Steeple Renewables Project

Applicant Comments on Deadline 5 Submissions

Document Reference: EN010163/EX/8.56

Appendix 1: Trench Plan

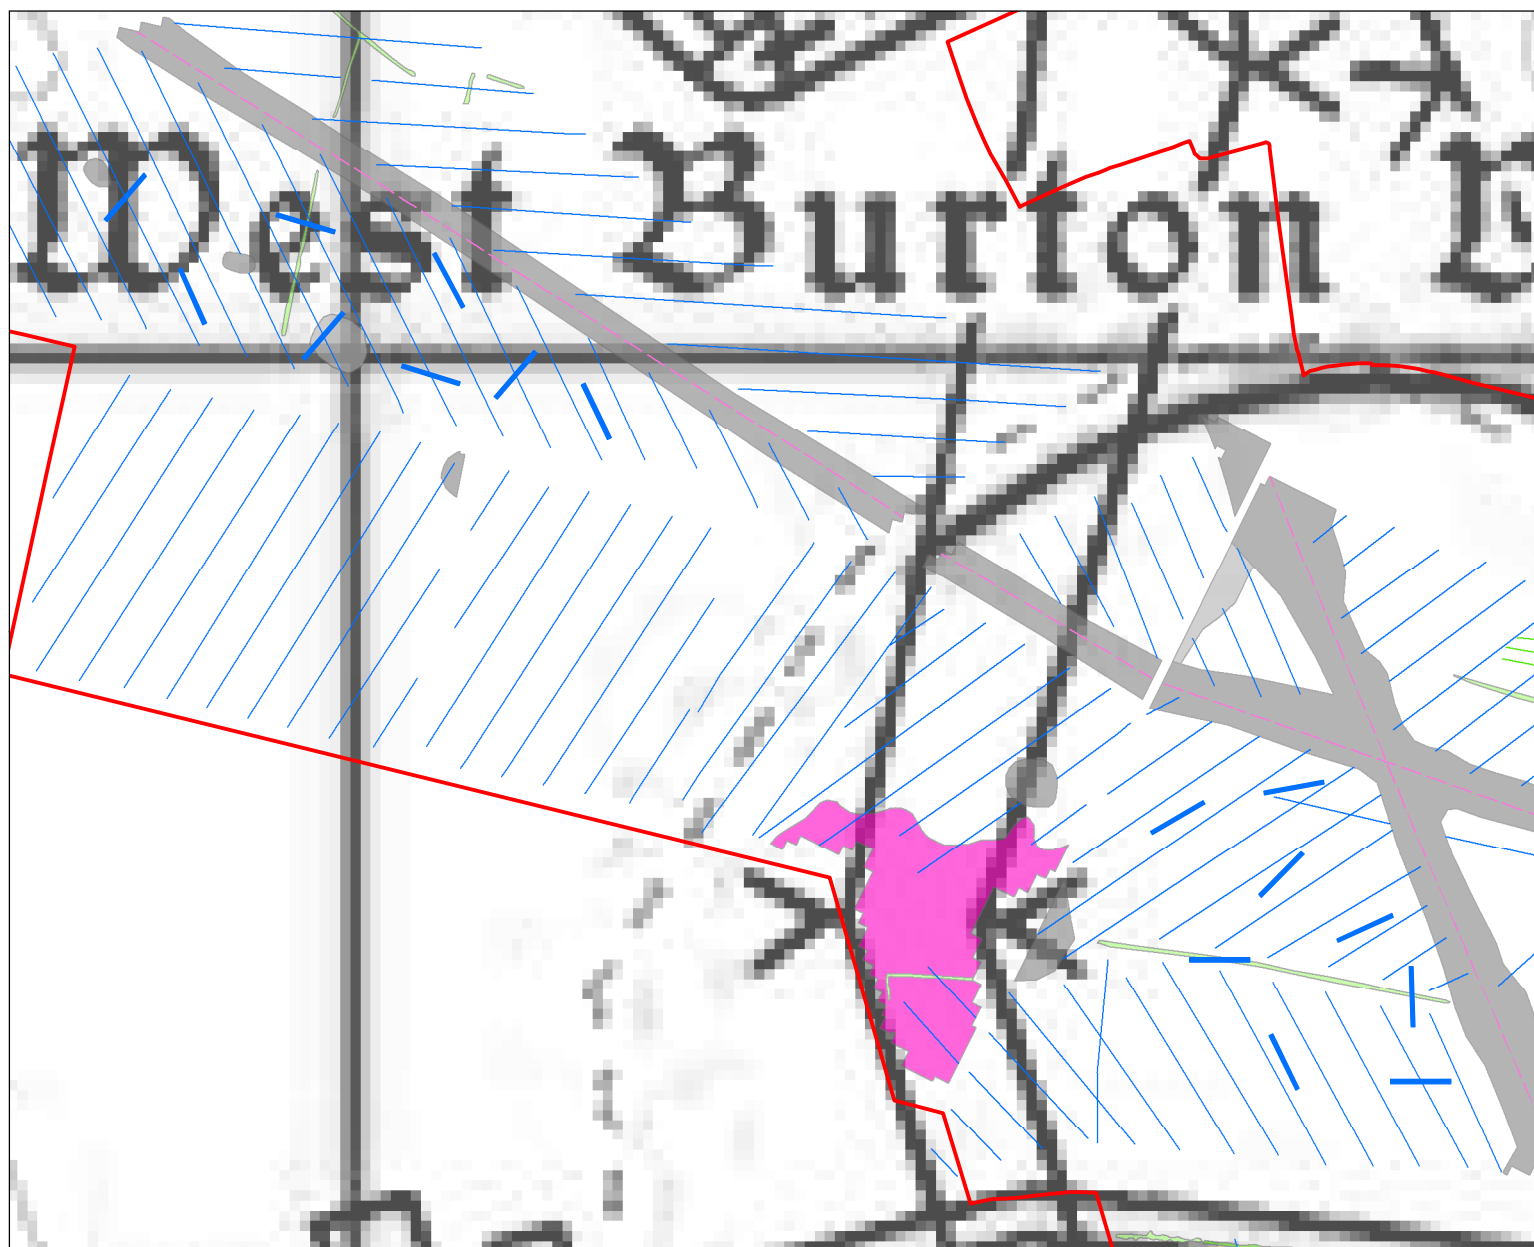
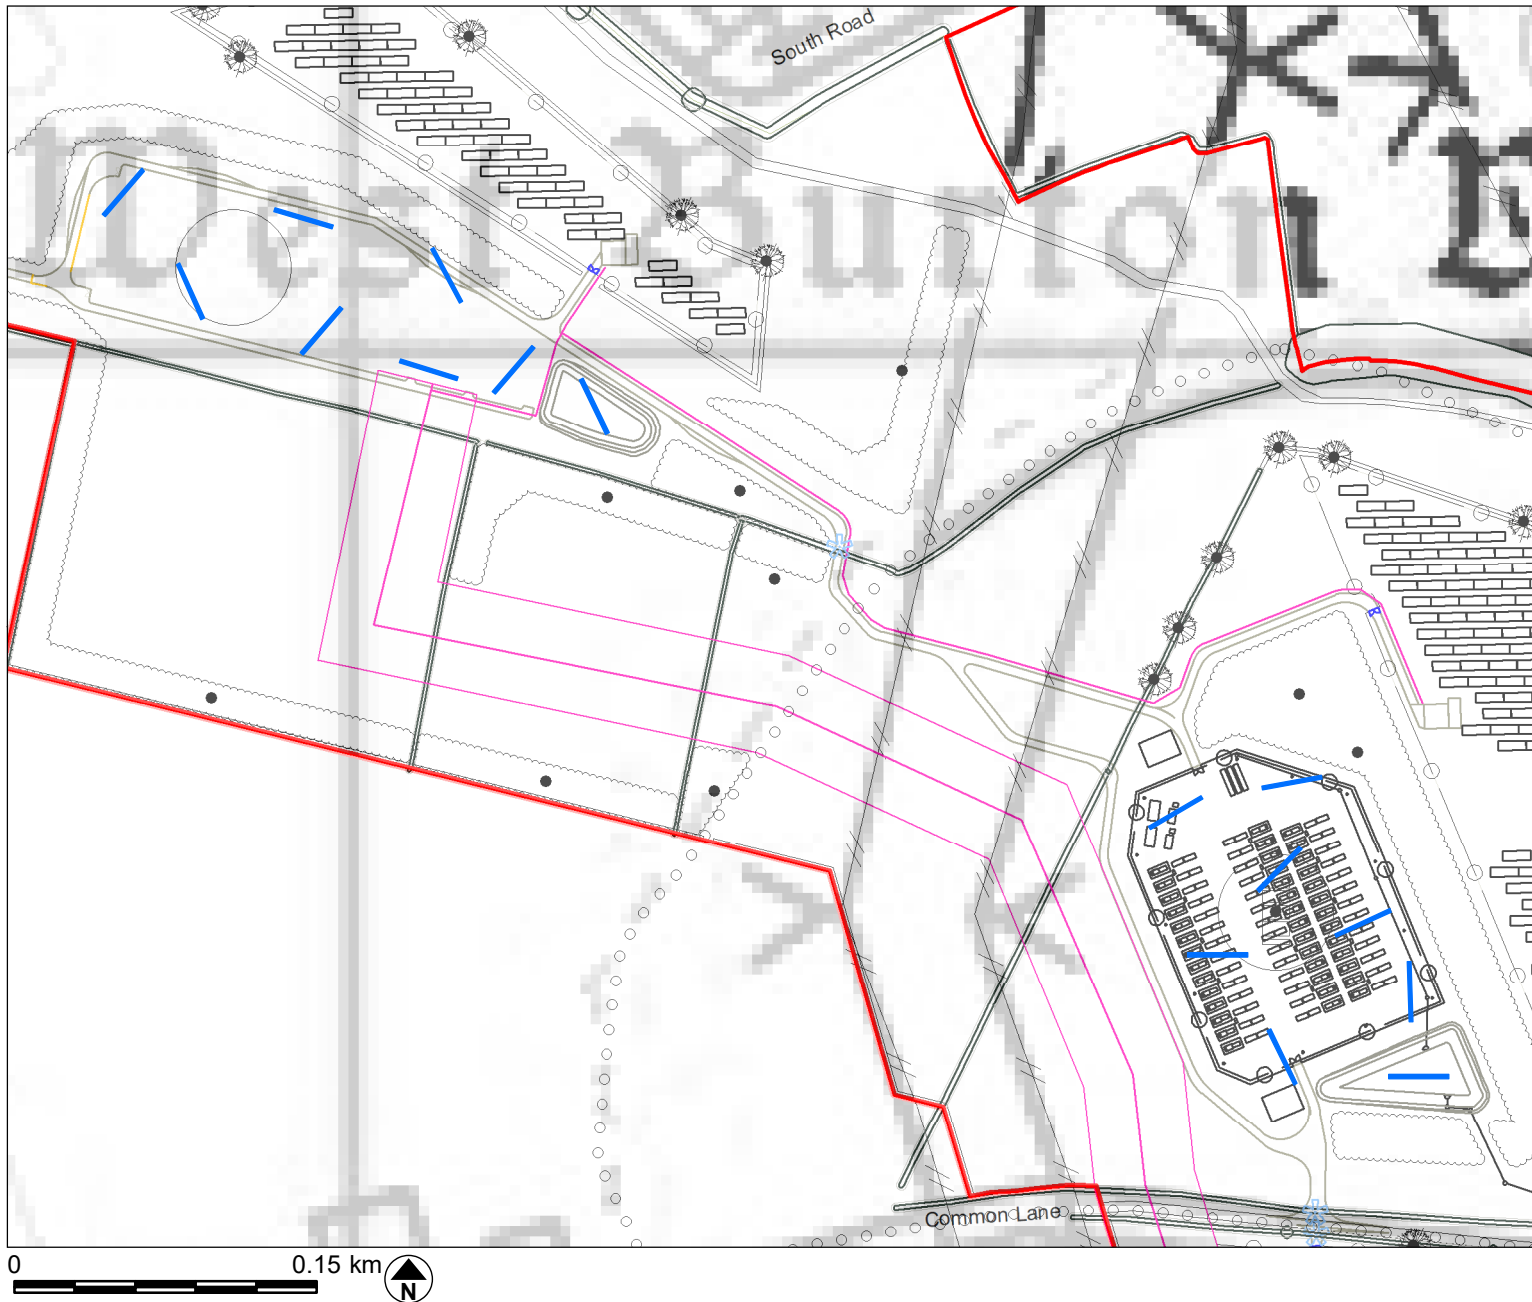
<p>REP5-055/6</p>	<p><i>Response of Nottinghamshire County Council:</i></p> <p><i>The paragraph does include that trial trenching areas 'will be agreed with the Archaeological Advisor(s)', however the scope for</i></p>	<p>Applicant has amended the paragraph as follows: <i>"Trial trenching will include areas of high archaeological potential, high impact and areas where non-intrusive survey assessment techniques have been unsuccessful (e.g. unsurveyable areas, areas of green waste etc.)."</i></p>

<p><i>post consent evaluation trenching will be necessarily much greater than the east of the site and the potential geoaerchaeological works on the palaeochannel. Given the current low level of trenching work and the large scale of potential post consent work to come, singling out a very small (but also important) part of it does not bring clarity to situation.</i></p> <p><i>A useful revision might include: ‘Given the substantial post consent commitment necessary to complete the evaluation work, trial trenching will include areas of high archaeological potential, high impact and areas where non-intrusive survey and desk-based assessment techniques have failed to adequately assess the archaeological potential or provide sufficient information on the character and significance of any archaeological remains present.’</i></p>	<p>This revised document is submitted at Deadline 6.</p> <p>The Applicant considers that this wording incorporates the substantive concern of Nottinghamshire County Council.</p>

## Appendix 2: Typical PV Module Rack Detail for Ballasted Foundations

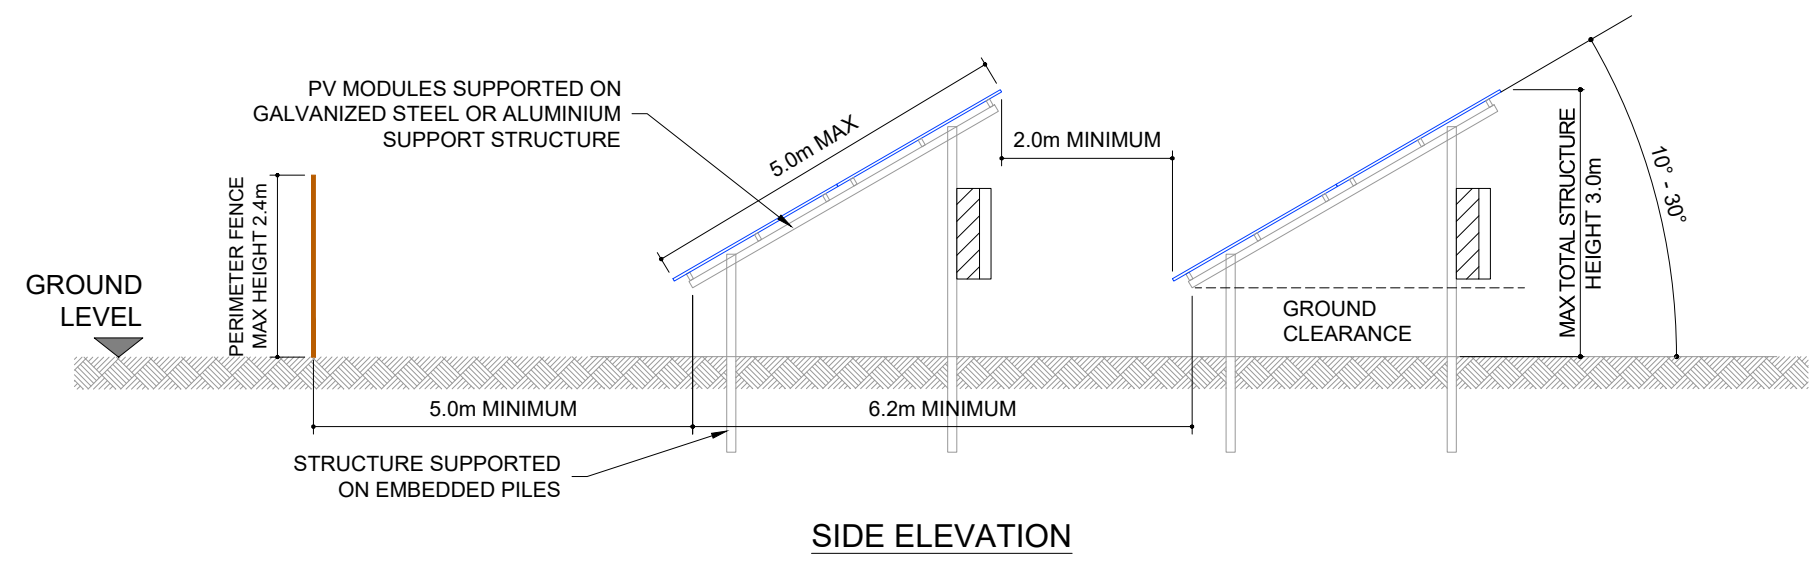
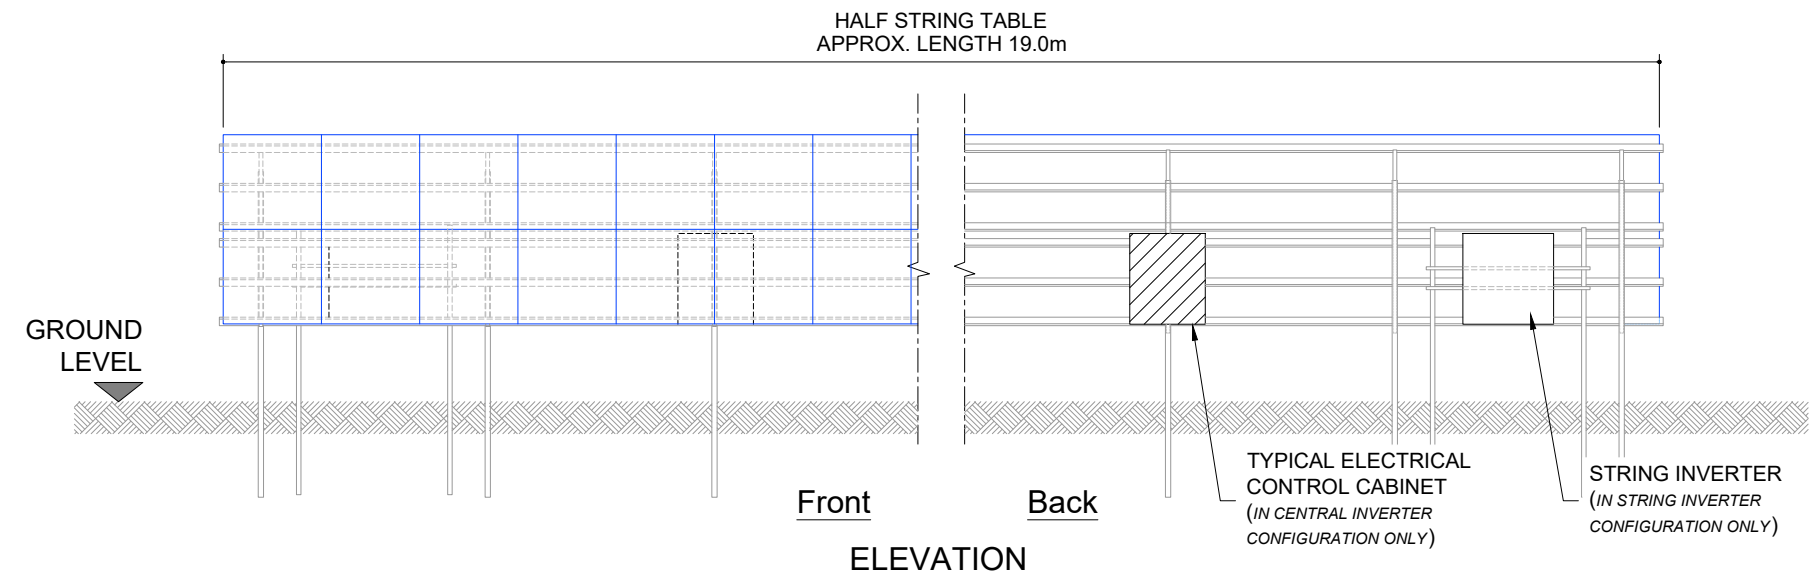
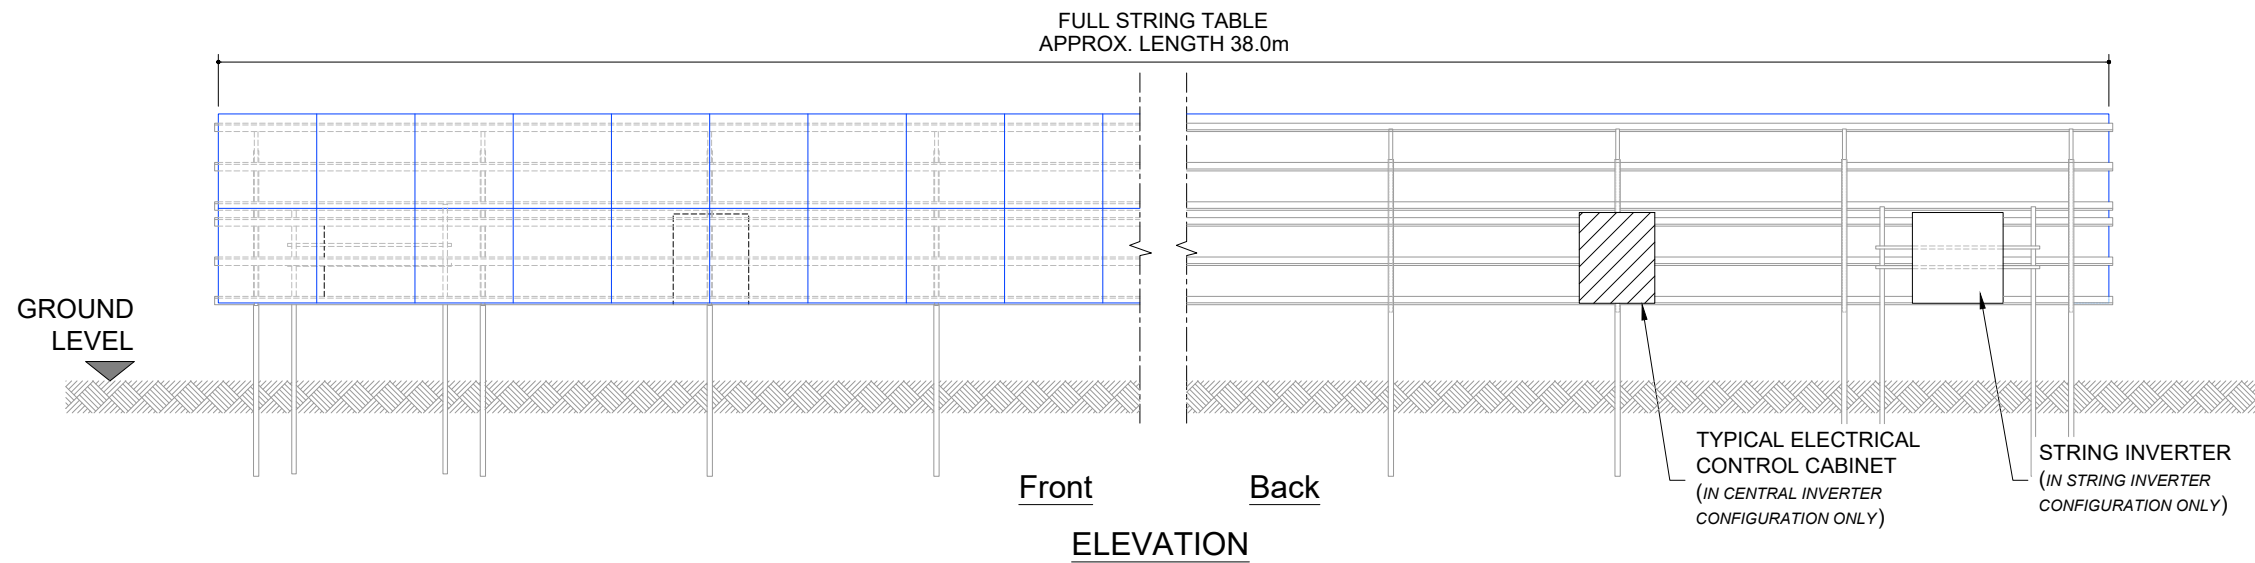
<p>REP5-055/10</p>	<p><i>Response of Nottinghamshire County Council:</i></p> <p><i>The use of ballast slab foundations as a preservation technique can be problematic. Primarily, the use as a preservation technique has not been tested sufficiently to establish its efficacy. In addition, this technique often requires ground preparation which in itself can be damaging to archaeological deposits, especially remains at a shallow depth. There are also significant concerns around ground compaction beneath the concrete slabs</i></p>	<p>The Applicant acknowledges that NCC have concerns, however the recommendations are essentially in line with the Applicant's response to Q11.0.8 from the Second Written Examiner's Questions (ExA Q2) [REP5-048], where it was identified that:</p> <p><i>"...Should any areas be identified during further evaluative works, which are considered particularly sensitive to development, e.g. significant archaeological remains are identified at very shallow depths, then other forms of mitigation are available, as appropriate, up to and including avoidance of installation any development in that area, as outlined in [APP-126]."</i></p> <p>Therefore, the Applicant considers that there is no change required to its proposed documents.</p>

<p><i>which will also have a negative impact on sensitive and shallow remains.</i></p> <p><i>The use of concrete slabs should always be informed by trial trench evaluation so that the depth, character and sensitivity of the remains being preserved can be properly understood and an assessment on the appropriateness of this technique presented as part of the mitigation strategy. For instance, it may be appropriate where sensitive archaeological remains are present at significant depth but would not be appropriate for shallow sensitive features such as those containing human or structural remains.</i></p> <p><i>Further assessment of the site-specific circumstances and details of the construction and implementation (including detail on decommissioning) would be required to assess the appropriateness of this mitigation strategy.</i></p>	
<p>REP5-055/11</p>	<p>Q13.0.3 Landscape mitigation</p> <p>Your position in the SoCG [REP4-032] (issue NCC 25) considers that any DCO should secure robust landscape mitigation, long-term management (for a minimum of 15 years), and post-establishment monitoring. Confirm the additions or alterations you are seeking to the dDCO, or application documentation, to address your concerns and whether this has been incorporated in other solar schemes.</p>
